Our Case Number: ACP-323742-25

Re: Proposed development comprises the development of an extension to the existing Burial Ground at Drumcliff Burial Ground located at the Townland of Drumcliff, Ennis, Co. Clare
Drumcliff, Ennis, Co. Clare

**Submission on application by Clare County Council for Burial Ground Extension at
Drumcliff, Ennis, Co. Clare.**

CLIENT: Clare County Council
TITLE: Watermain & Storm Water Sewer Layout

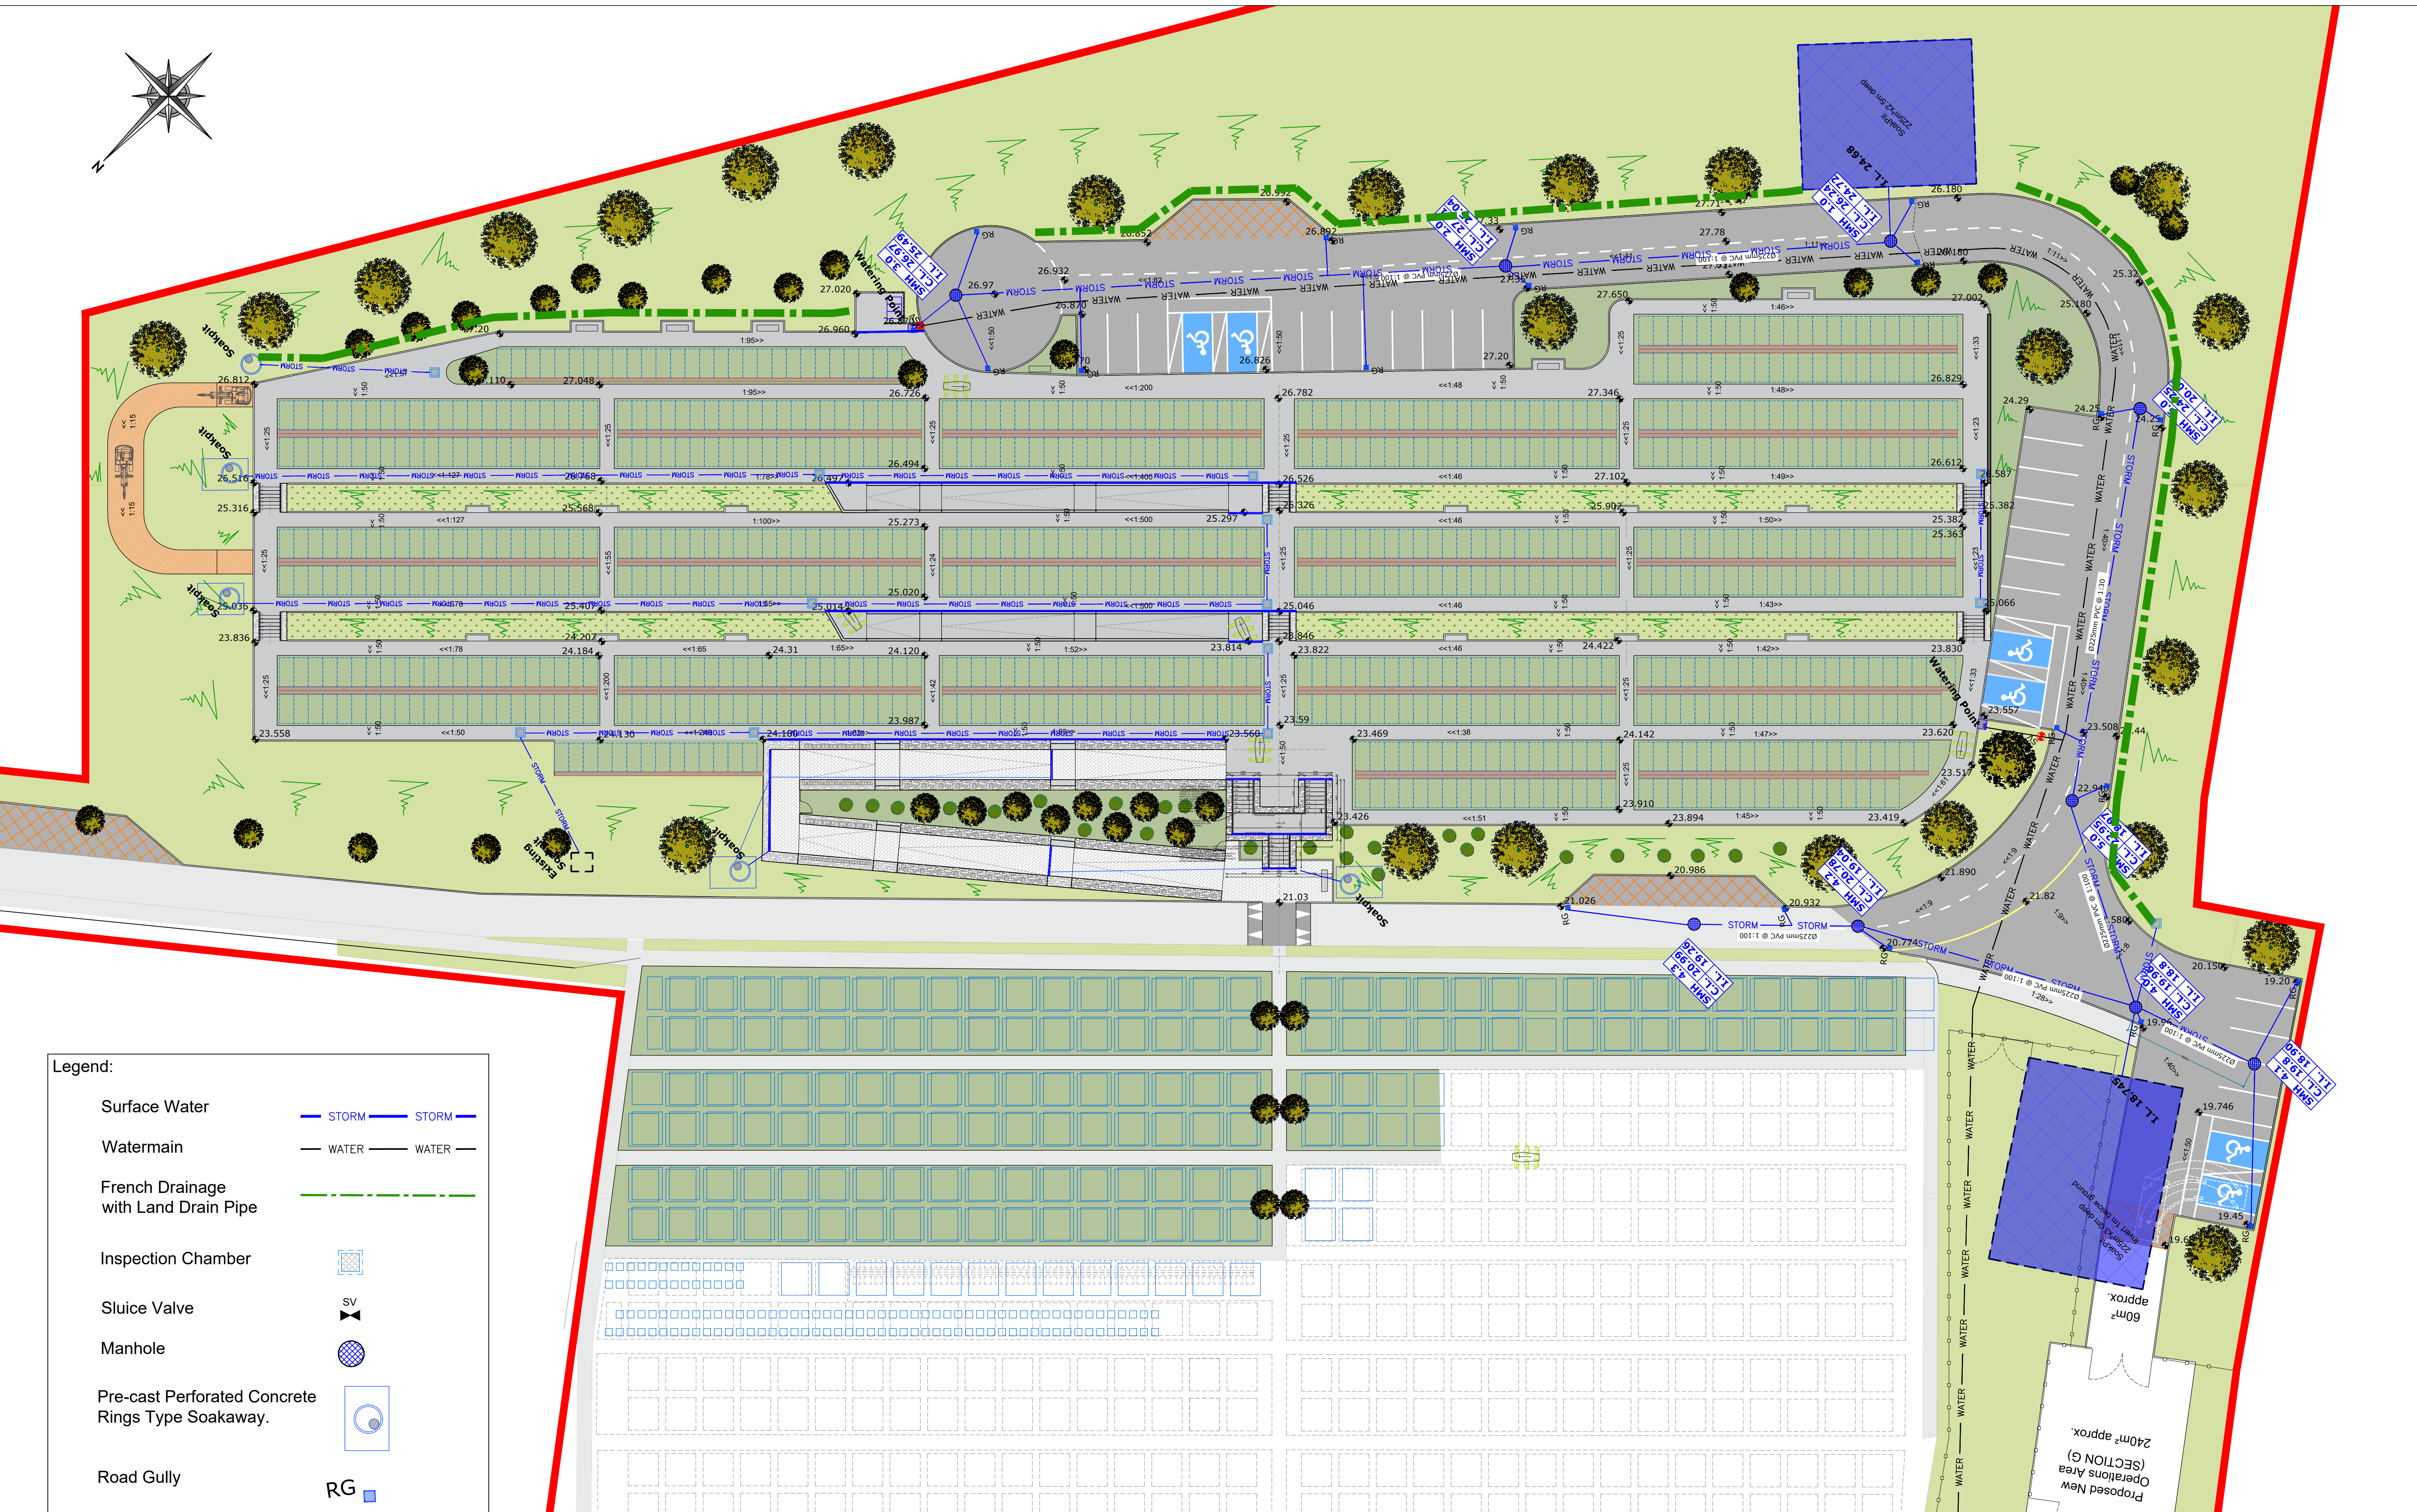
I wish to make the following submission/observation with regard to above application. I live in my family home adjacent to above development on family farm/landholding that has been in my family for generations and while i am not opposed to extending the graveyard i have serious concerns especially with regard to drainage and storm water disposal connected to the development. In recent years any work undertaken at graveyard has led to flooding of public road adjacent my dwelling and indeed my farmlands so much so that i had to install a pumping system to take away flood water from my lands to an exit point uphill and across my lands to a safe non-impactful area. It should be noted that i have had to do this at considerable expense to myself and that this flooding to my property was never an issue until recent times and due to continuous work around graveyard. I also note that application is proposing 2 No soakaways but can this guarantee adequate and sufficient disposal of stormwater/ground water etc and prevent flooding to my property and indeed, public road with its associated public safety issues. I cannot keep incurring financial burdens to keep flooding out of my property due to circumstances not of my making.
